COMMENTS ON APPELLANT'S STATEMENT

Planning Inspectorate Reference:	APP/T2350/W/24/3348576
LPA Application Reference:	3/2022/0942

Change of use from private dwelling (C3) to Hotel/Holiday Let (C1) and retention of unauthorised detached building for use as Hotel/Holiday Let (C1).

Thorneyholme Hall, Newton Road, Dunsop Bridge BB7 3BB

PWL ARCHITECTURE
 Title
 Proposed Annex
 Building - General
 Arrangement

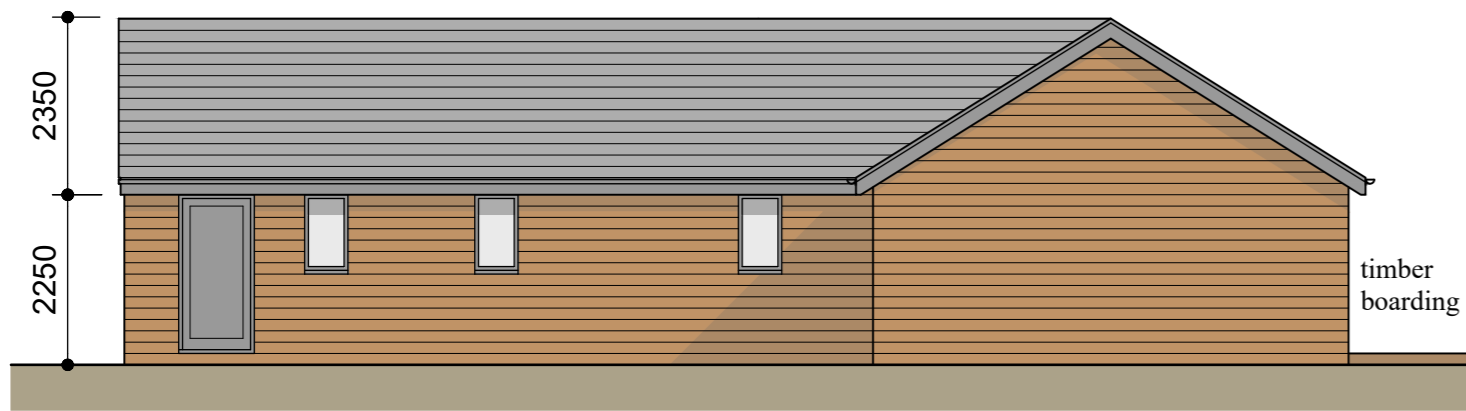
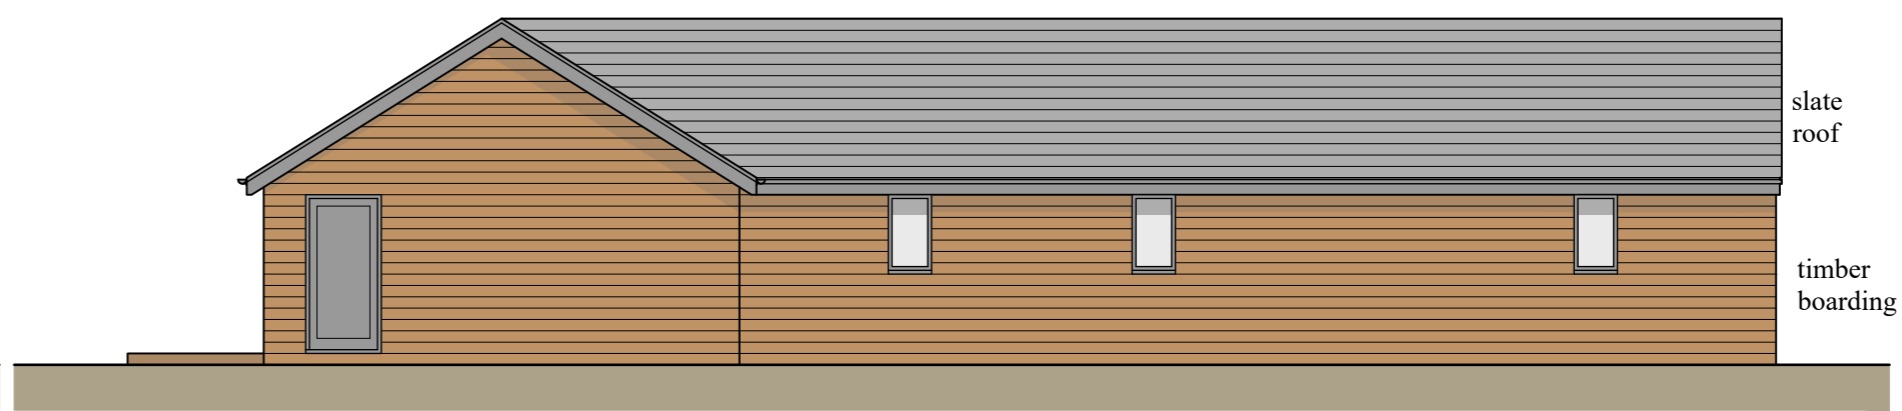
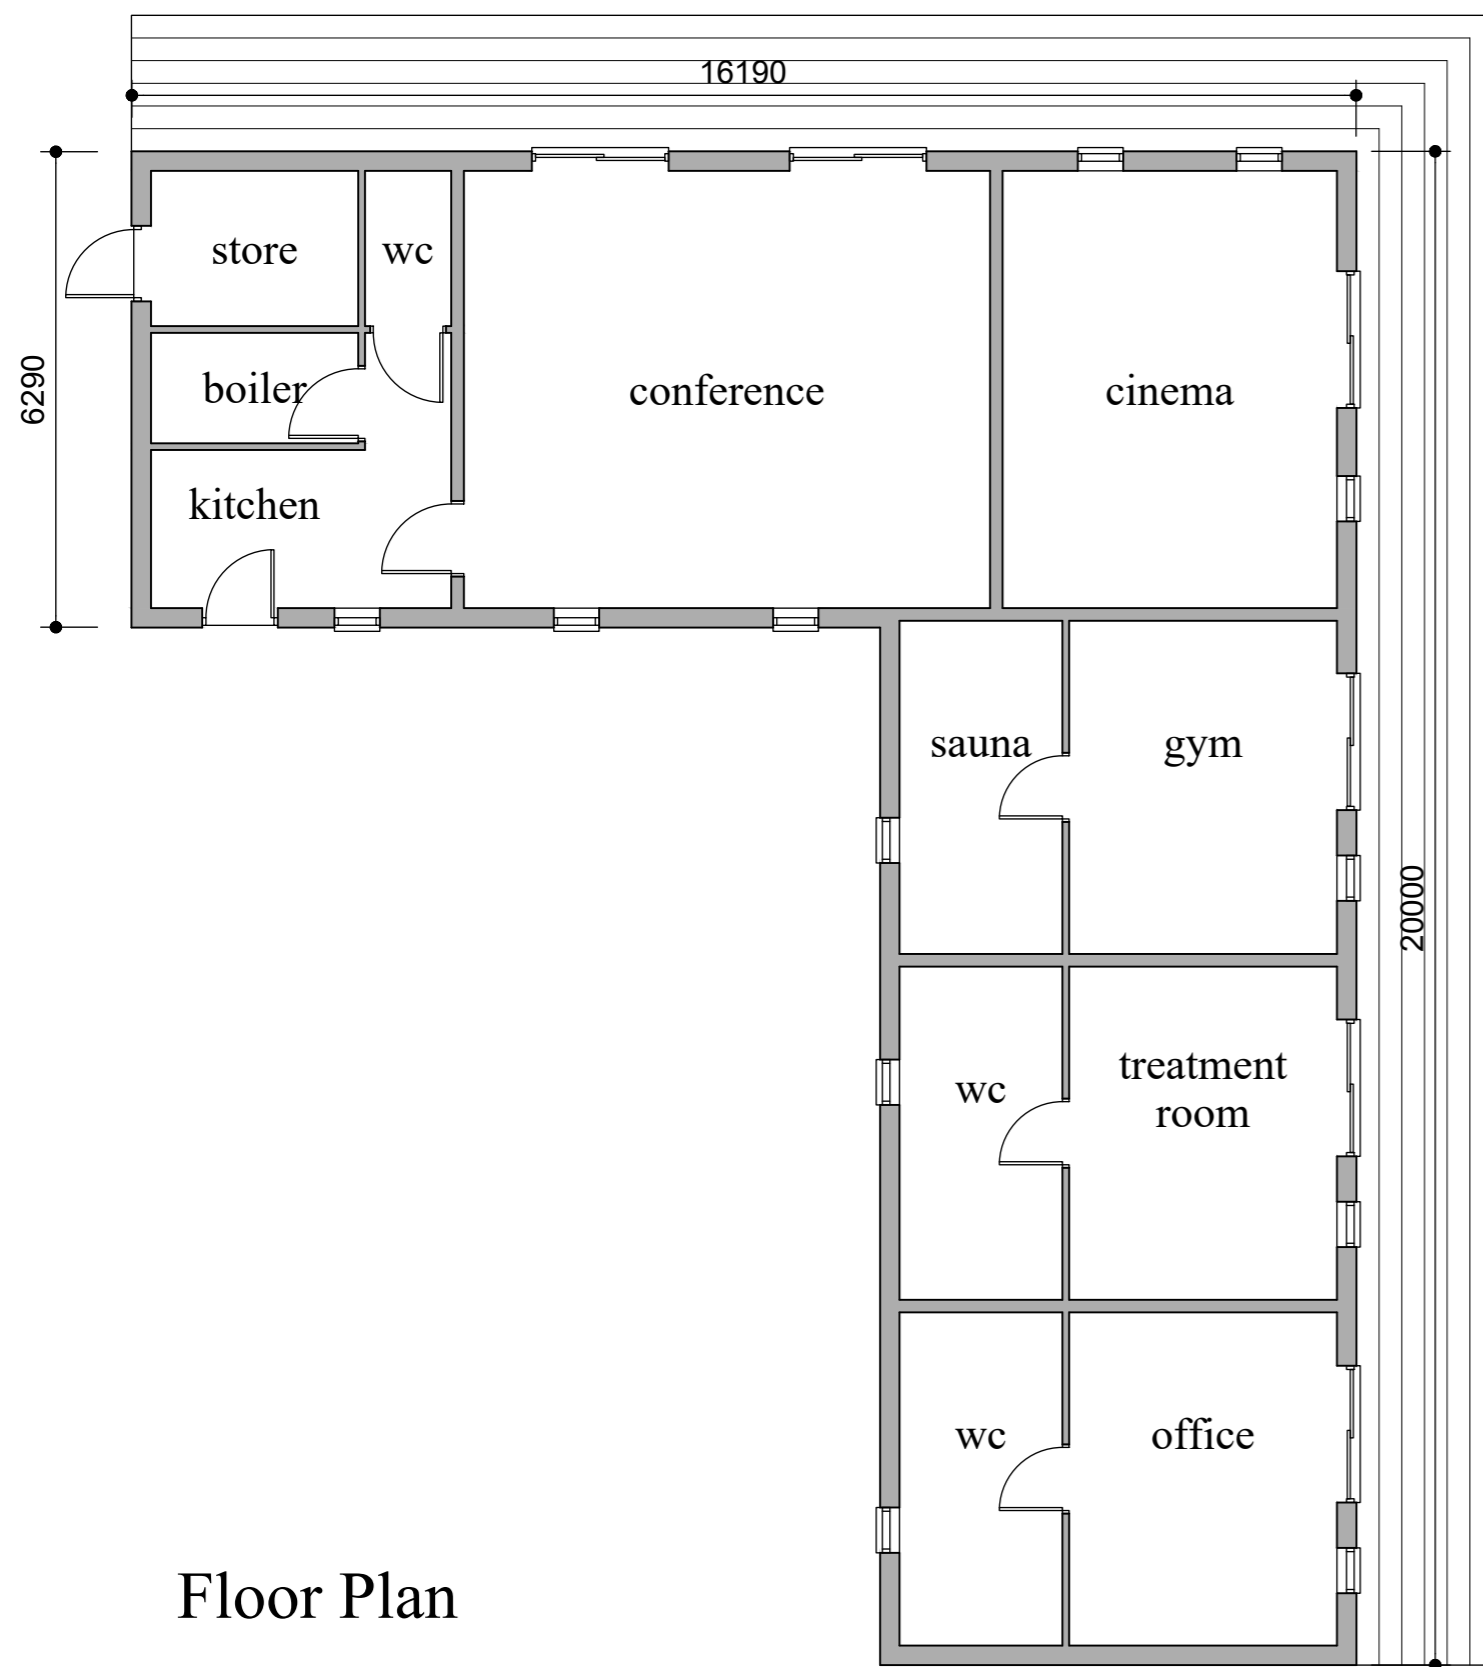
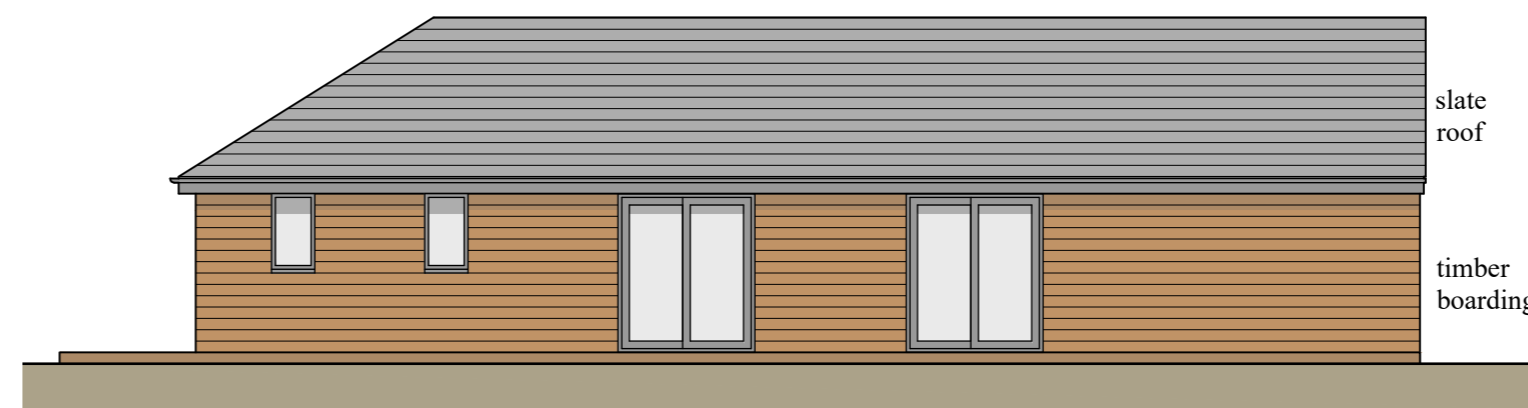
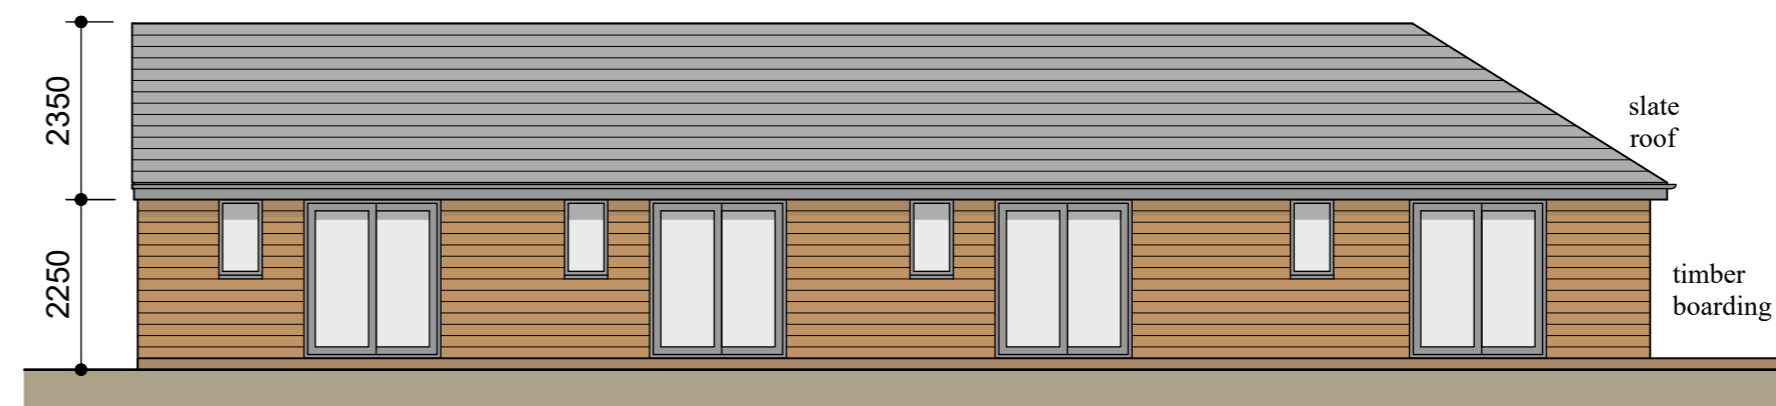
1. The outbuilding has been erected without consent. Whilst the LPA consider that the change of use of the main building from a dwelling house into a hotel use would be an acceptable one, and indeed the main building has been previously used for such a use. However, concerns remain over the use of the building as a holiday let and the lack of information that has been submitted in relation to the unauthorised outbuilding and its retention within the Forest of Bowland National Landscape despite prolonged email discussions relating to this and the proposed use and requests for existing floorplans for the outbuilding as built.

4. Nothing has changed since that decision and clearly the building constructed bears no resemblance to the garage building that was previously on the site

and approved for conversion as part of the cookery school which has not been implemented. Therefore, the outbuilding has no permission in its current format and as such this building has no defined use.

14. It remains the view of the LPA that the unauthorised outbuilding does not have a use and since the cookery school permission has not been implemented and with no prospect of it doing so, then there is no realistic fallback position and the outbuilding is not an acceptable form of development within the Forest of Bowland National Landscape and should be removed.
